**IN THE MATTER OF AN APPLICATION TO
AN BORD PLEANALA**

**For Approval of the Railway (Metrolink – Estuary to Charlemont via
Dublin Airport) Order [2022]**

ABP-314724-22

Schedule of Errata

Drawing Title  
Figure 14.3 Groundborne Noise from Mechanical Excavation  
Sheet 3 of 7

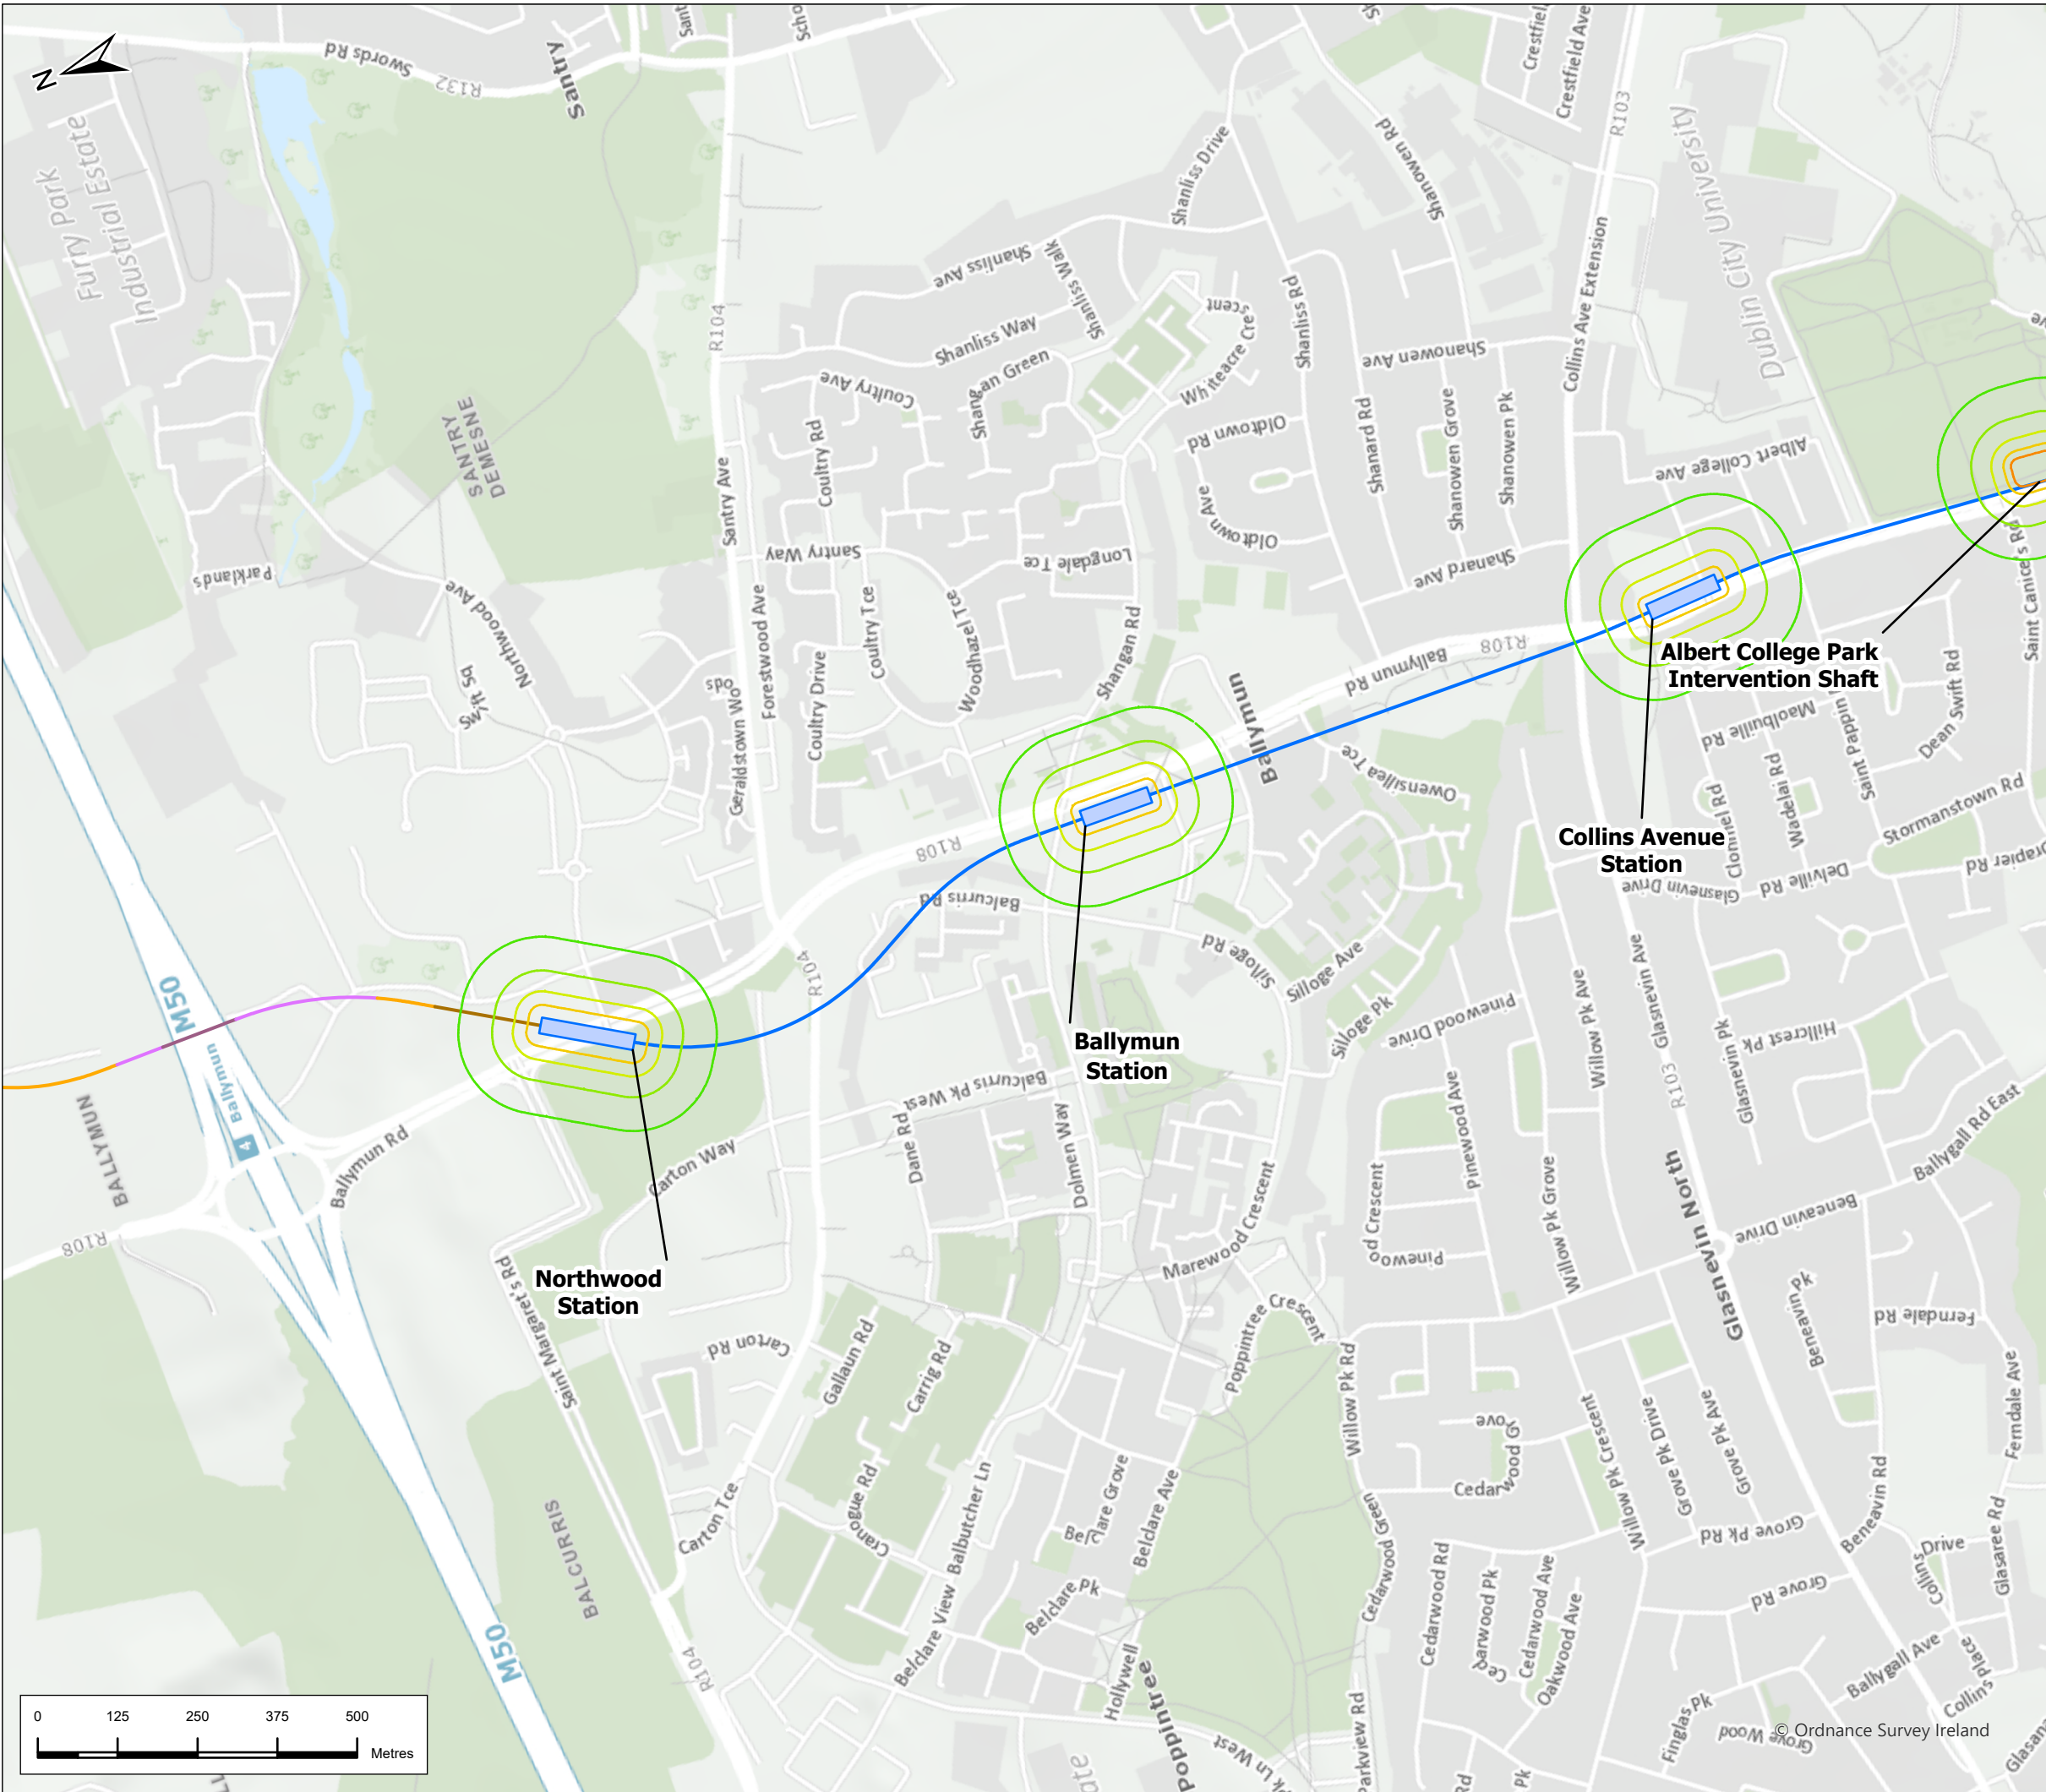
32.	EIAR Chapter 14 Groundborne Noise and Vibration	n/a	all pages	Title of Figure is not correct	Change Title from "Vibration from Mechanical Excavation" to "Groundborne Noise from Mechanical Excavation".

Figure 14.7 Groundborne Noise from the Mechanical Excavation of Intervention Tunnels  
Sheet 2 of 2

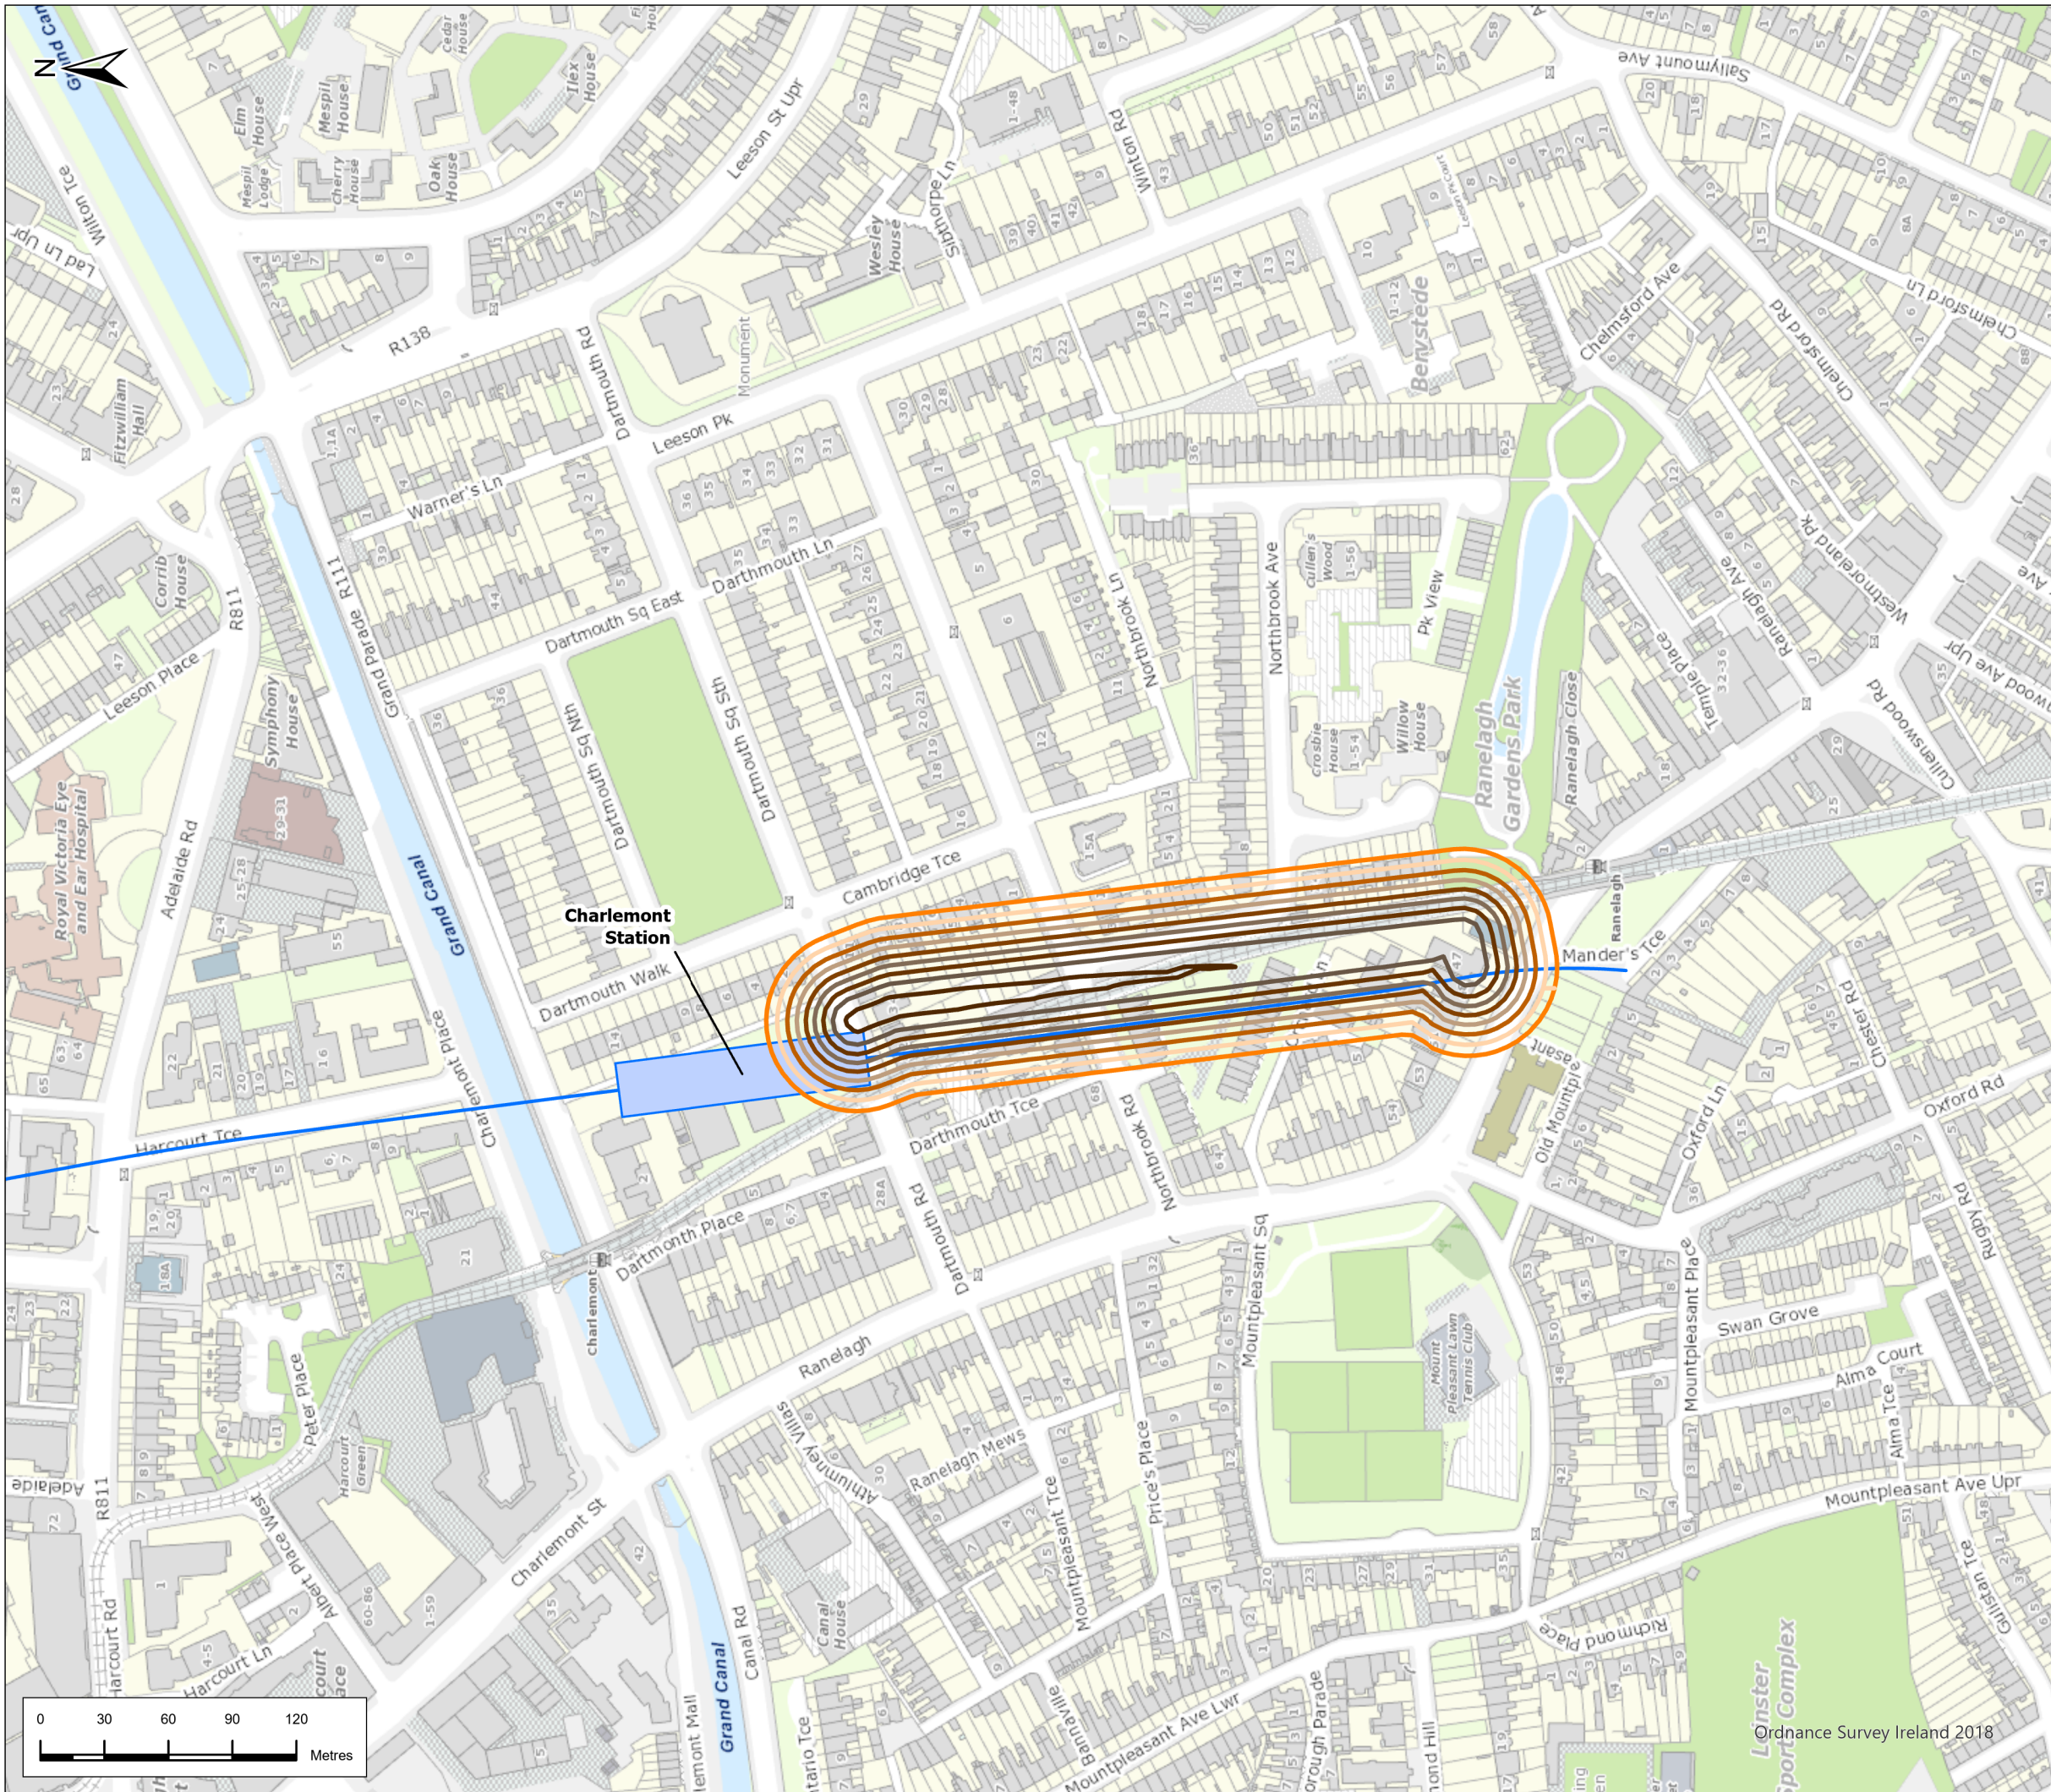
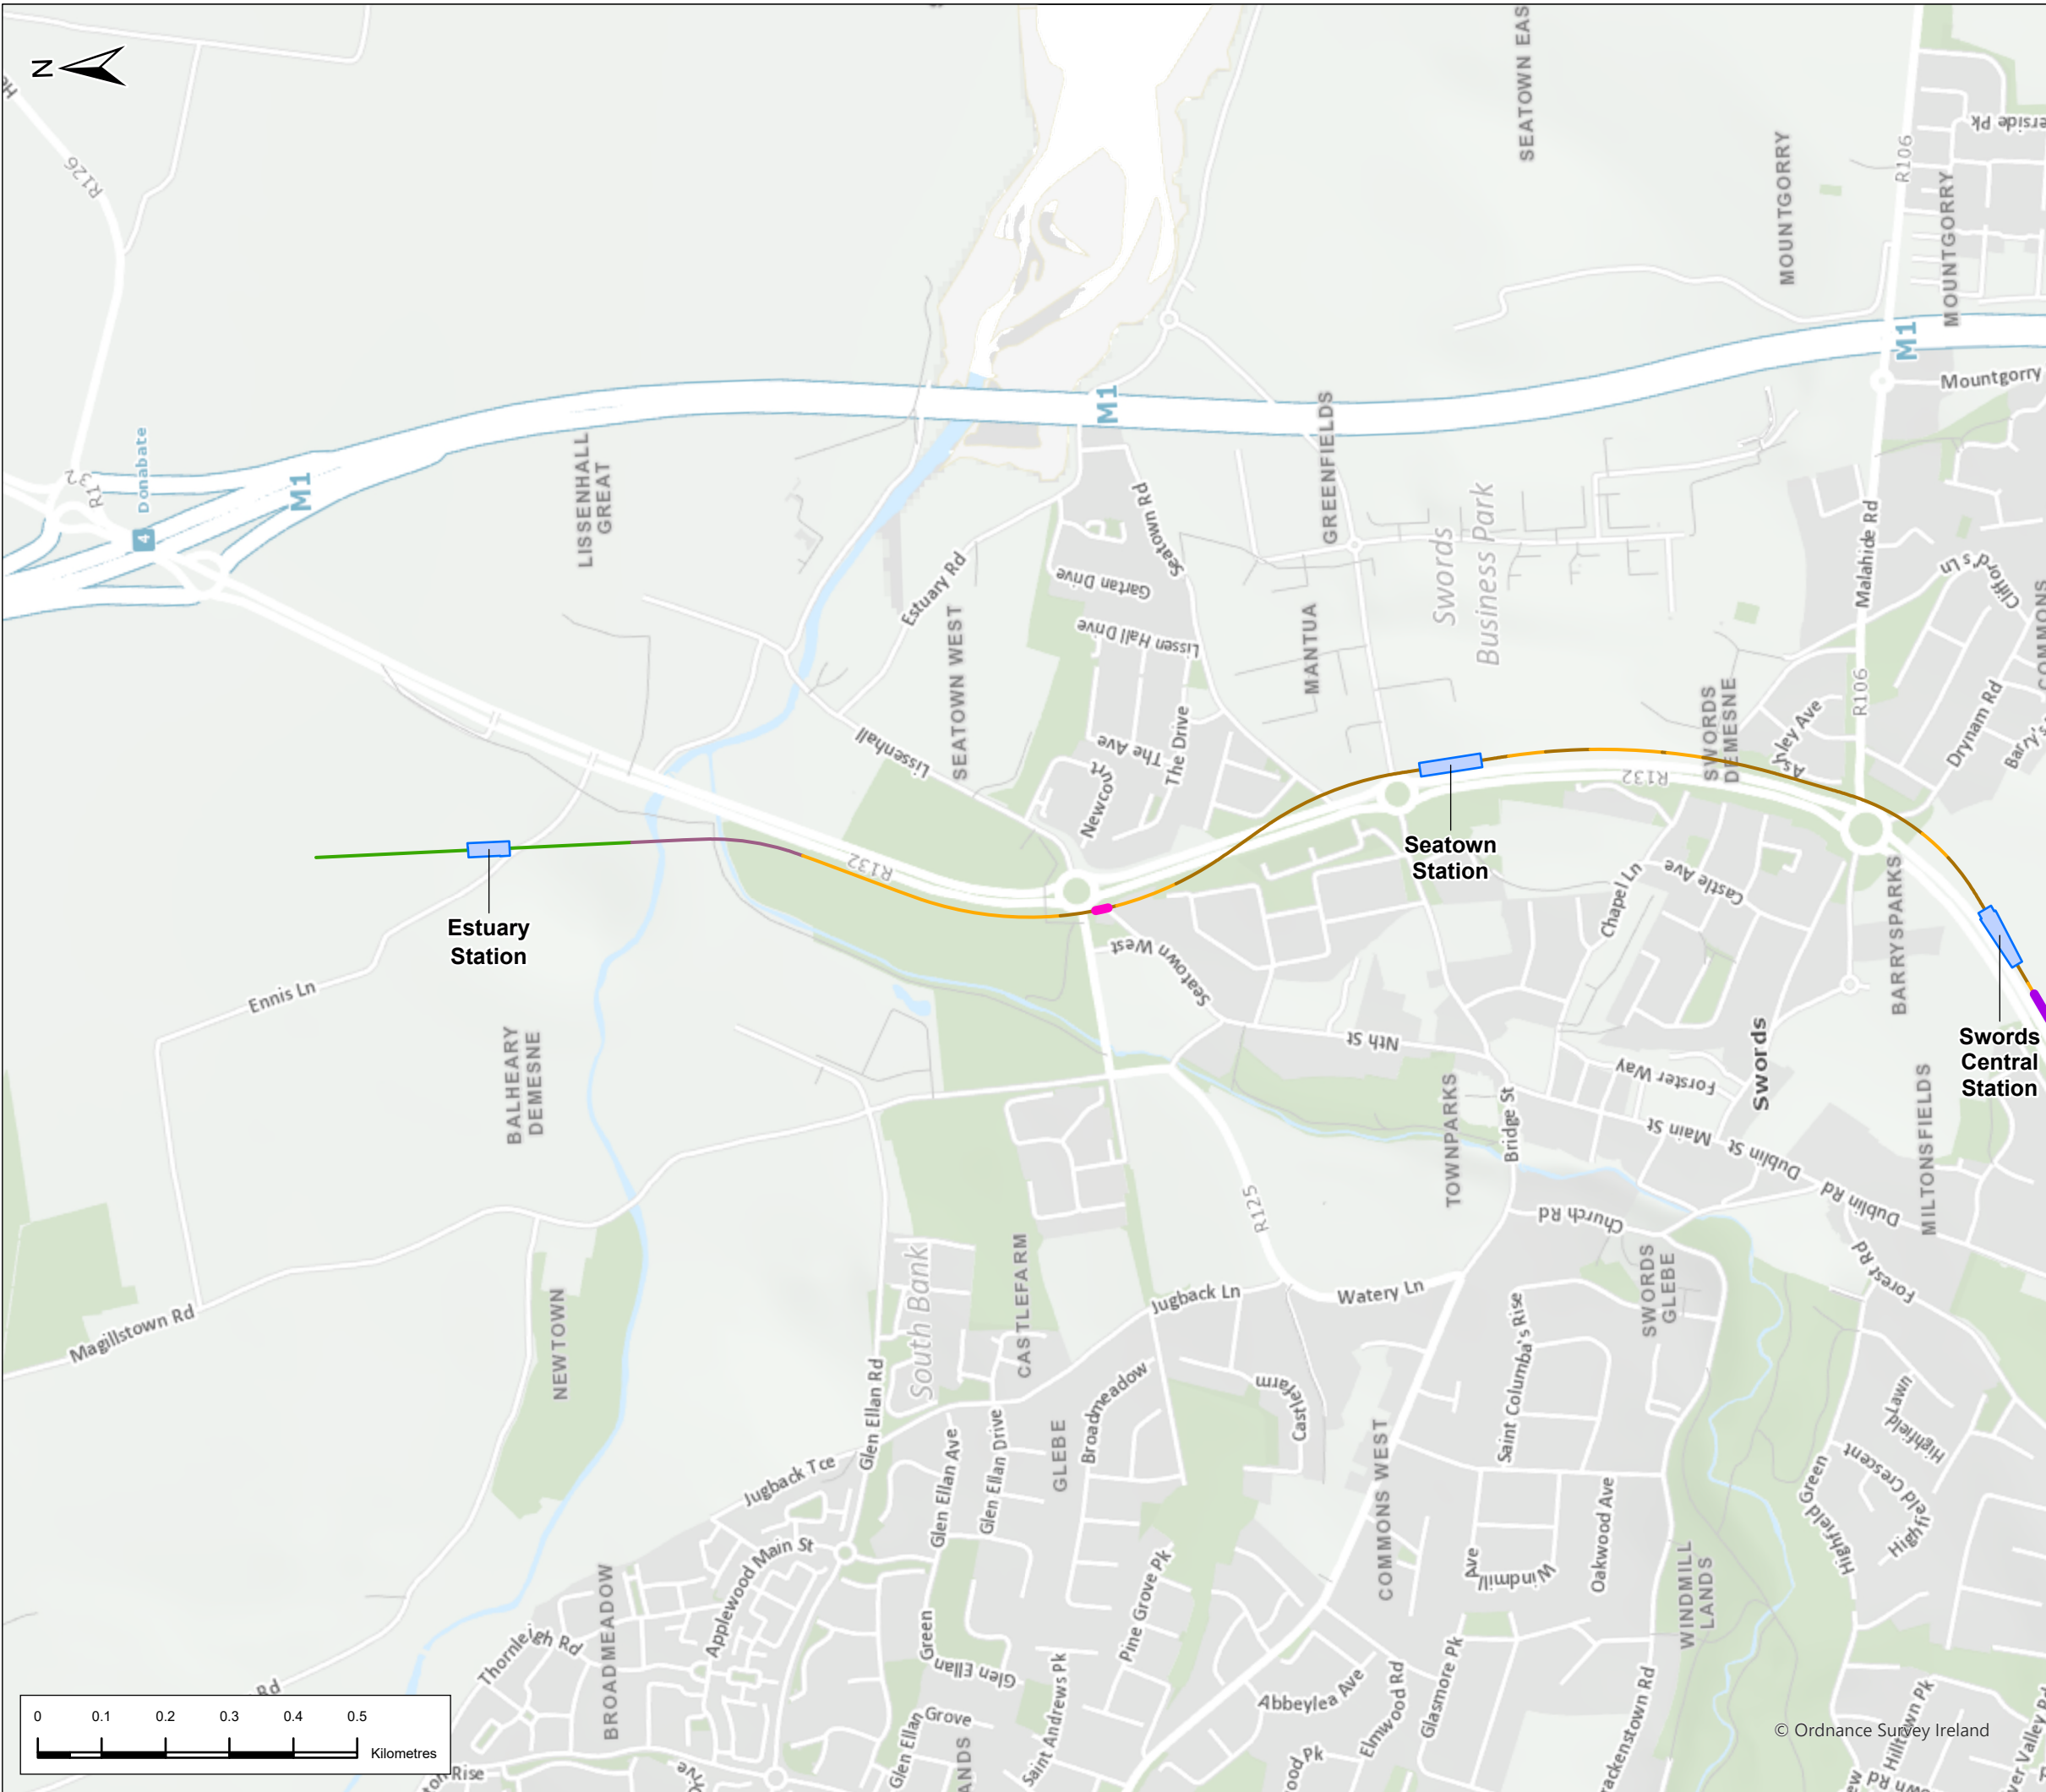
34.	EIAR Chapter 14 Groundborne Noise and Vibration	n/a	n/a	Additional Figure, adding groundborne noise contours for the mechanical excavation of the intervention tunnels.	Additional Figure, adding groundborne noise contours for the mechanical excavation of the intervention tunnels. Please refer to Appendix 12 Updated and Additional GBNV Figures.
